Re: M/56/15/HH - 31 Sea Way, Middleton on Sea, PO22 7RZ

Having discussed with our client, we wish to amend our proposal and submit the following substitute plans:

- 14029-03-A (Plans)
- 14039-04-A (Elevations and sections)
- 14039-06-A (Block plan)

14039/04

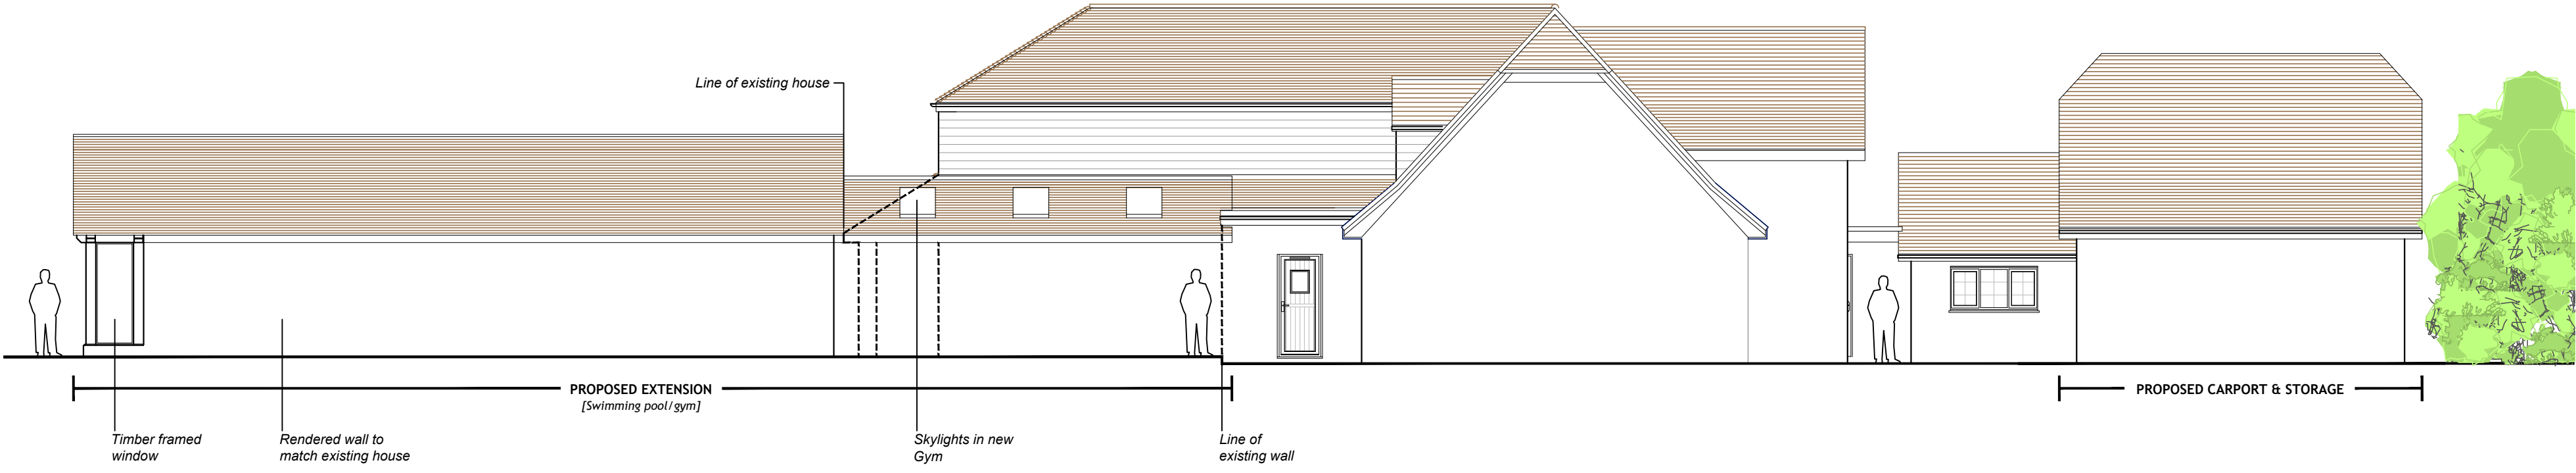
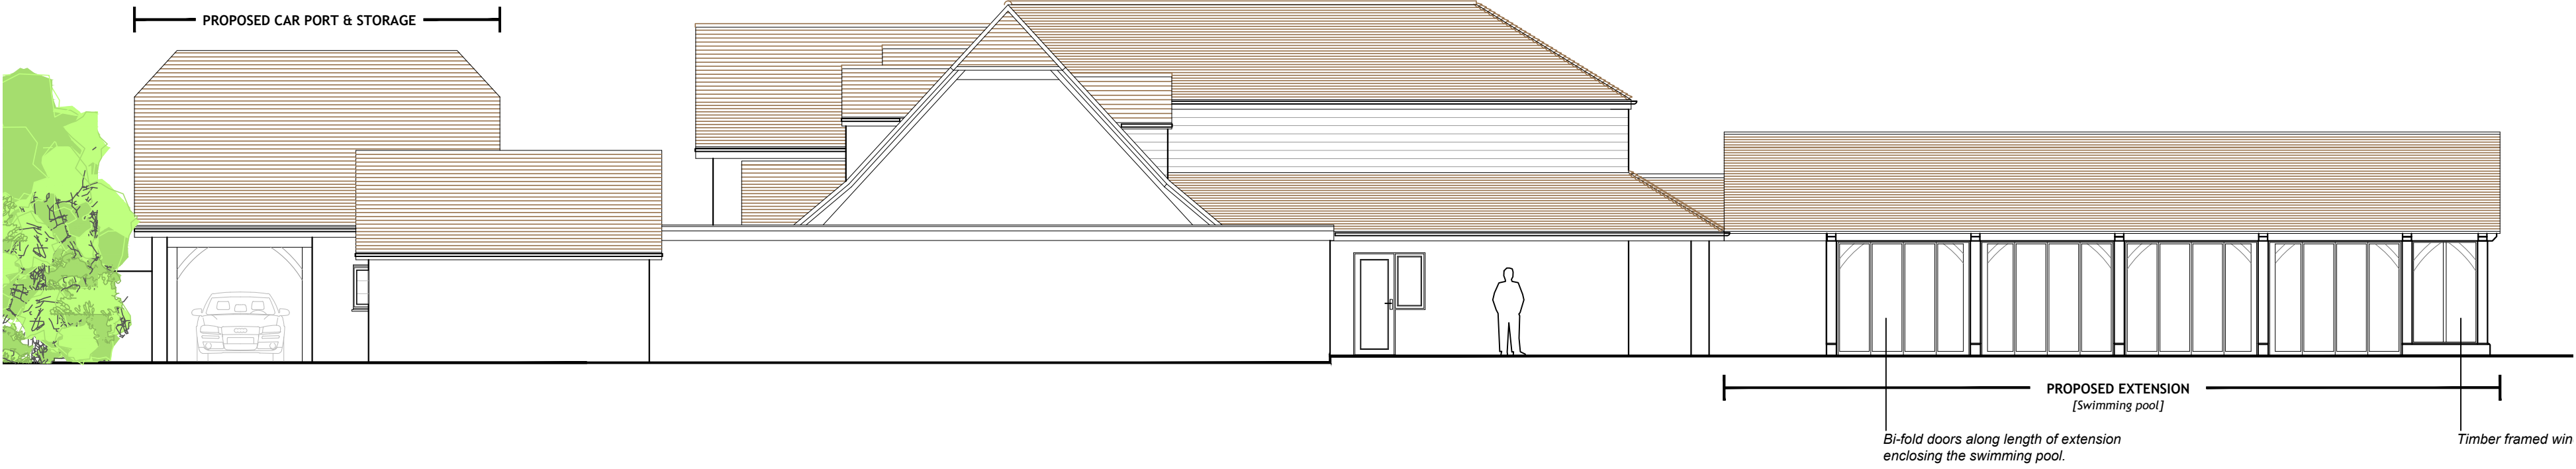
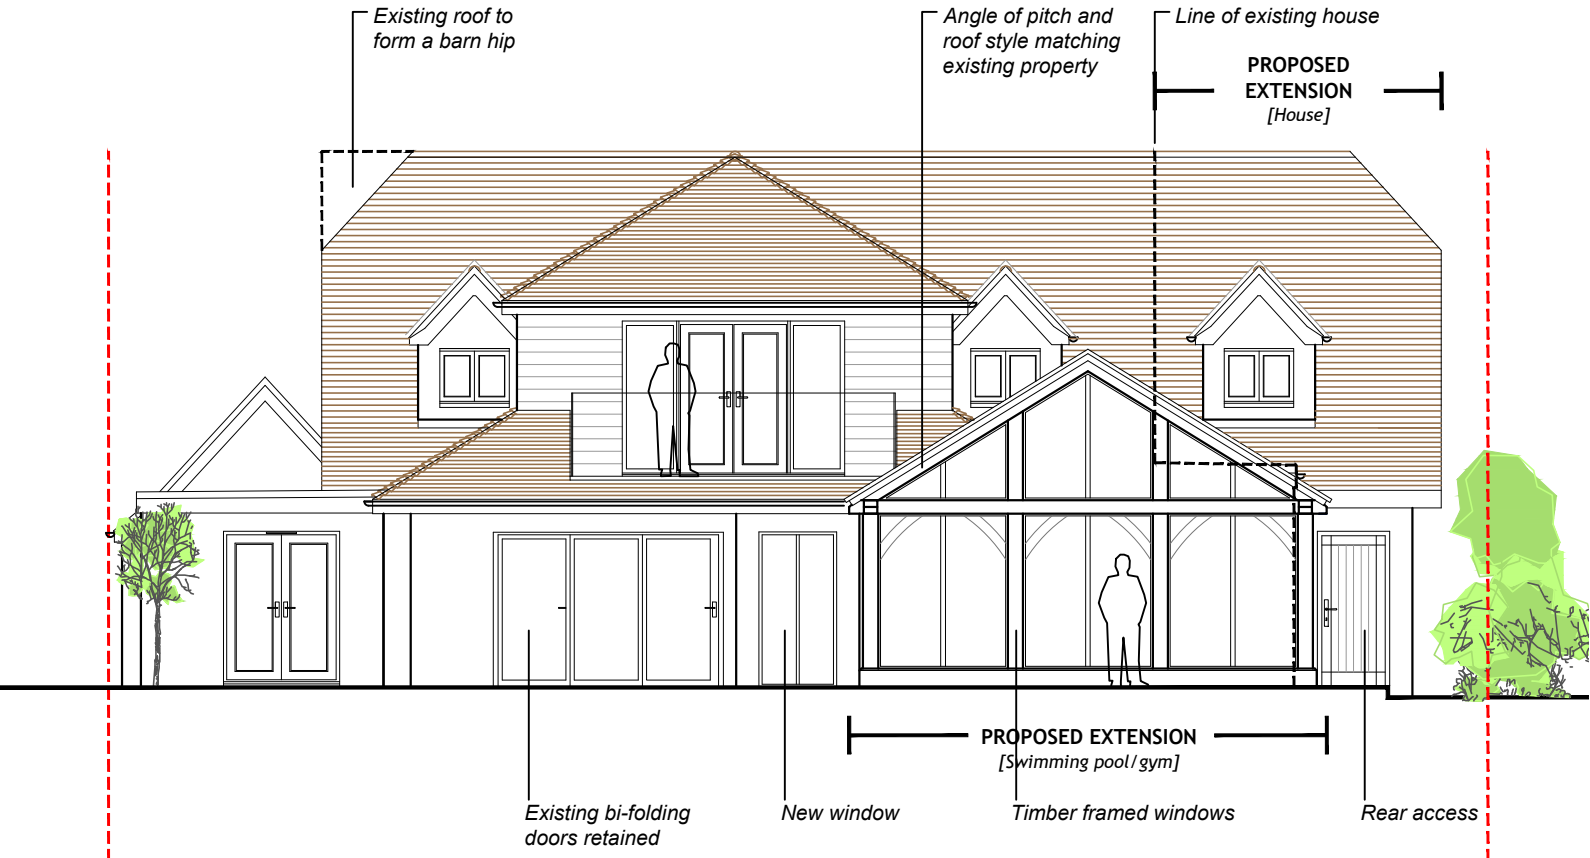
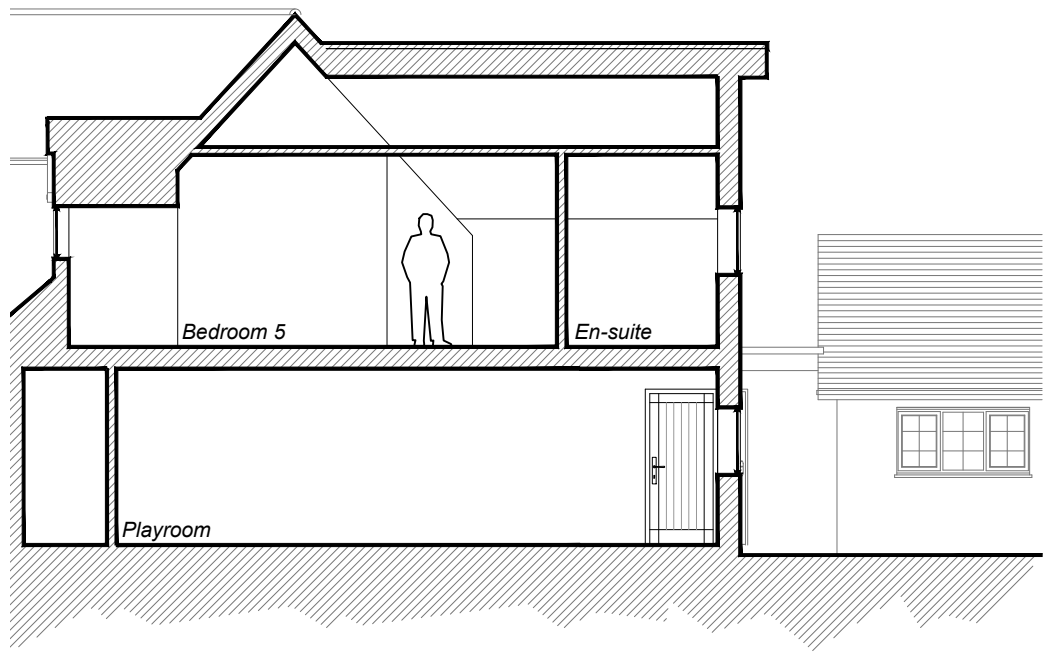
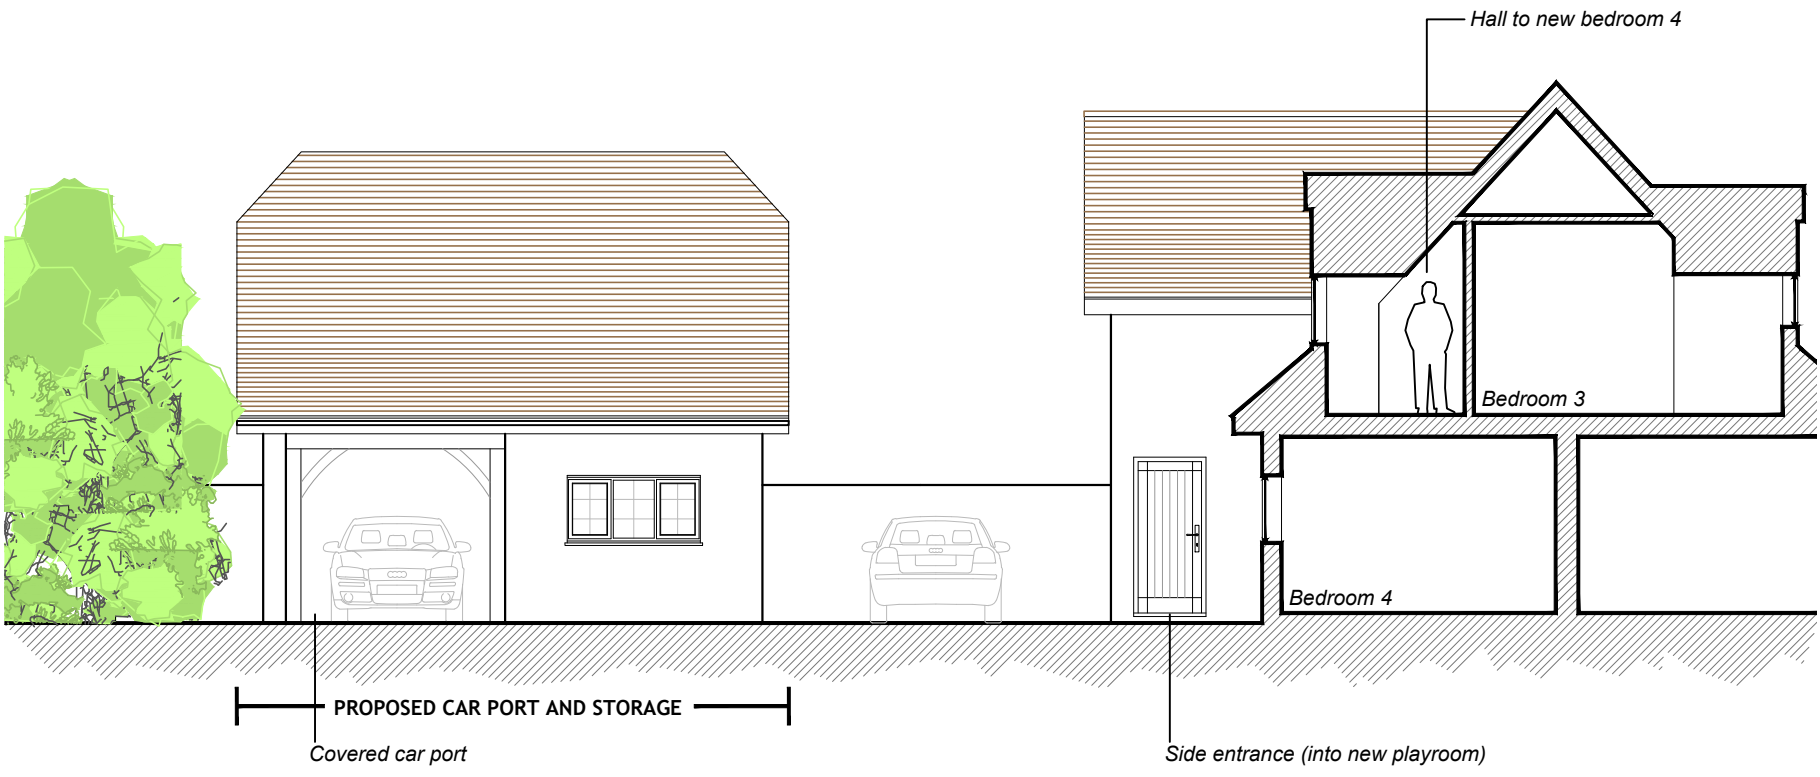
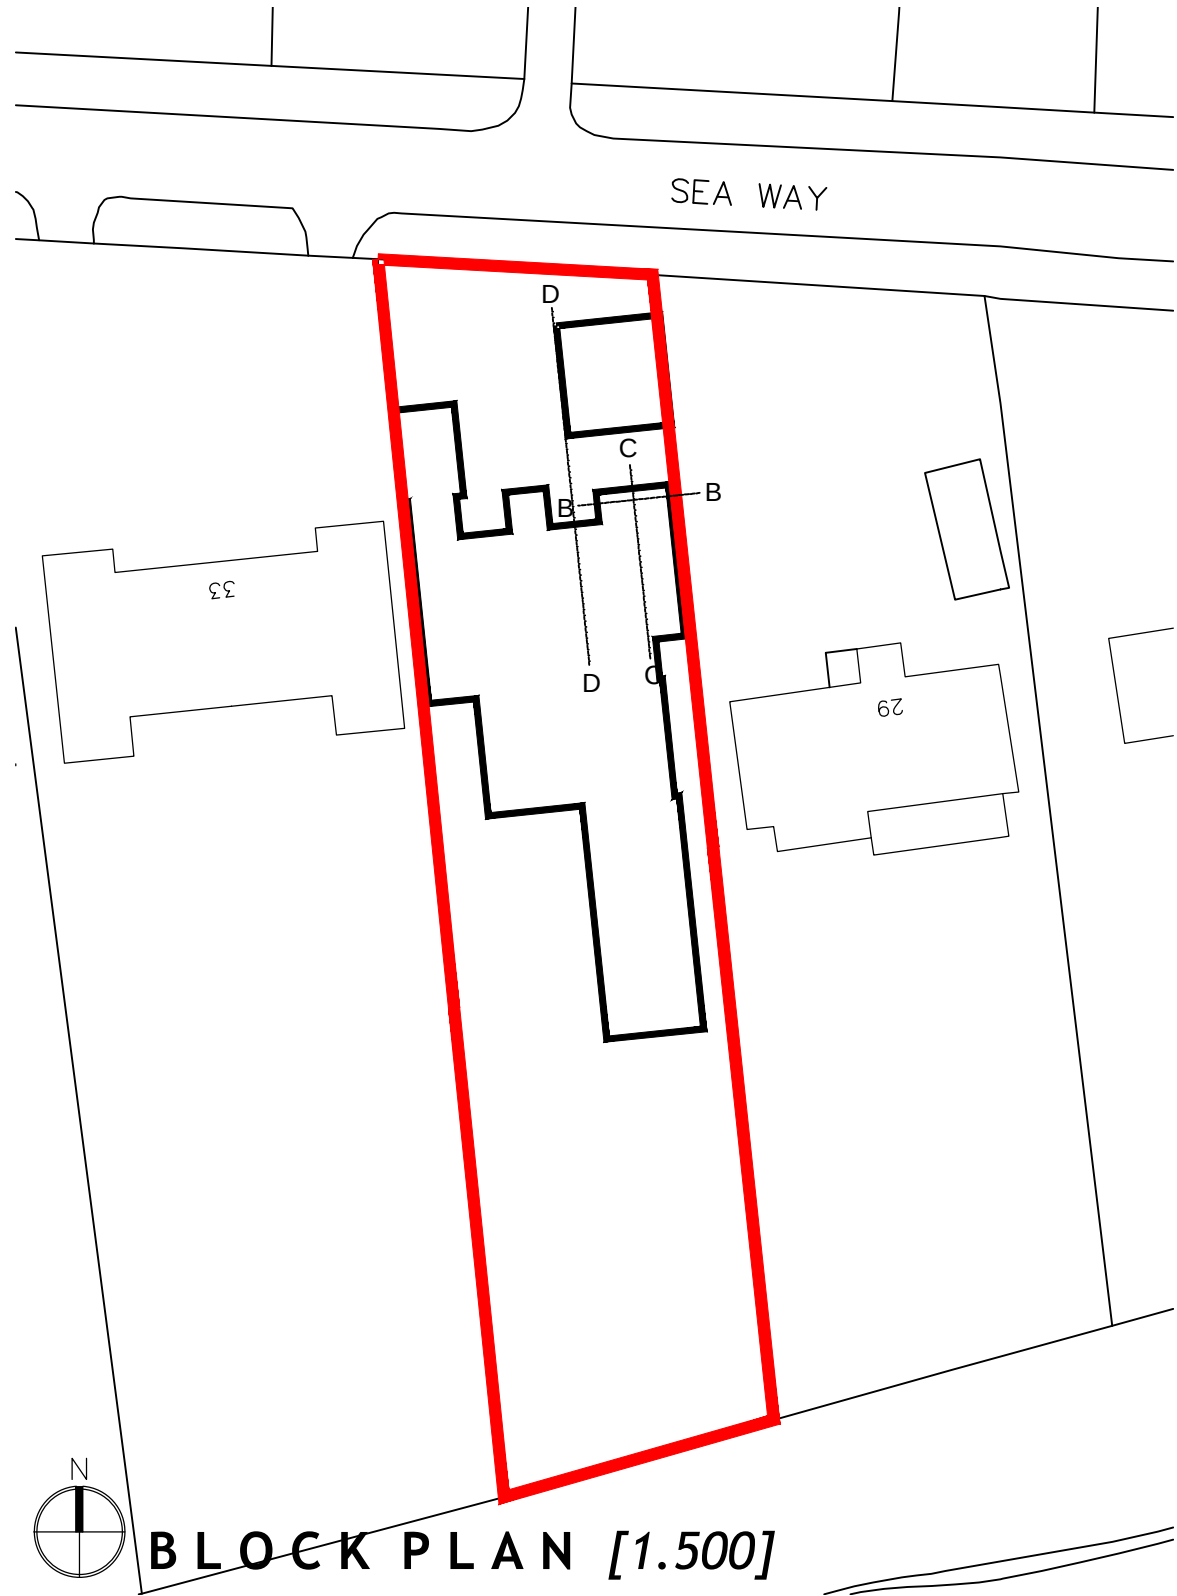
1. Omitting the proposed carport to the front of the property.
2. Reducing the pitch of proposed extension to enclose the existing swimming pool from 31.6° to 25°. This reduces the height of the ridge by 480mm.
This roof is proposed to slope away from the boundary so it does not overpower the boundary with No29 Sea Way. The shrubbery along the boundary between 31 and 29 Sea Way is to be retained which will help screen the proposed extension.
